Euroley Poultry Production Complex (SSD 6882)

RESPONSE TO SUBMISSIONS

1 September 2015

TYPICAL SECTION THROUGH SHEDS

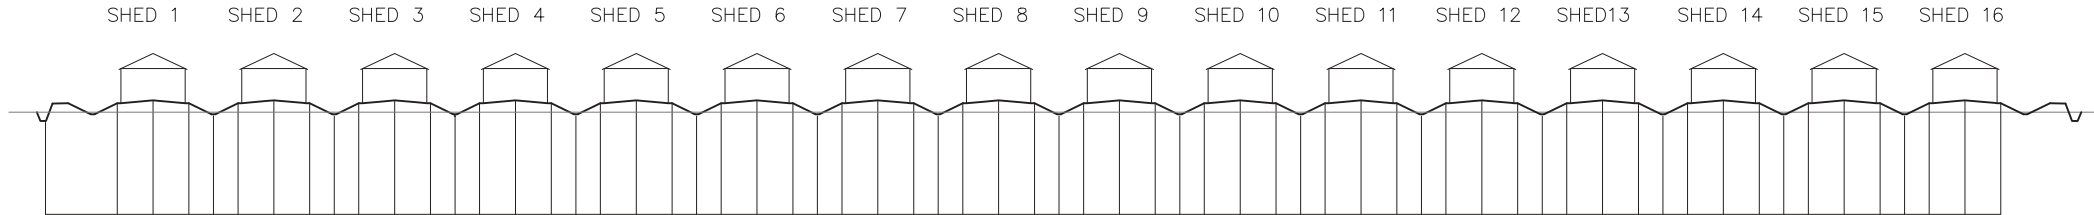
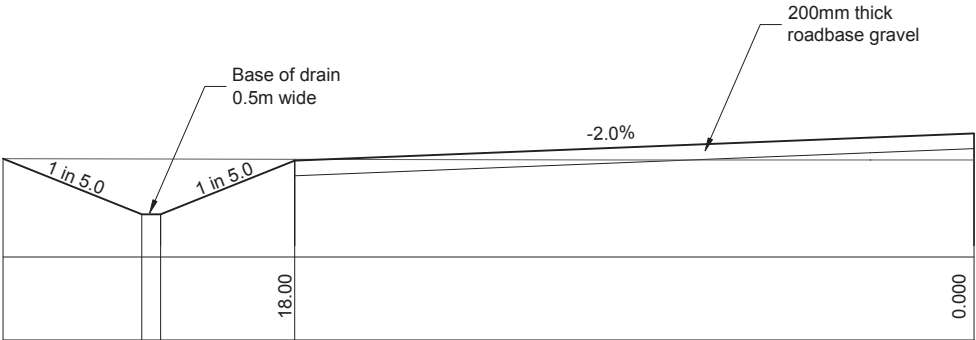
The cut and fill volumes required to construct the development should be quantified.

Cut and fill quantities required to construct the Project have been calculated by LRCE, and are presented on the plans provided in **Appendix A** for each PPU (refer LRCE drawing numbers C03 (PPU5), C04 (PPU 4), C05 (PPU 3), C06 (PPU 2) and C07 (PPU 1)).
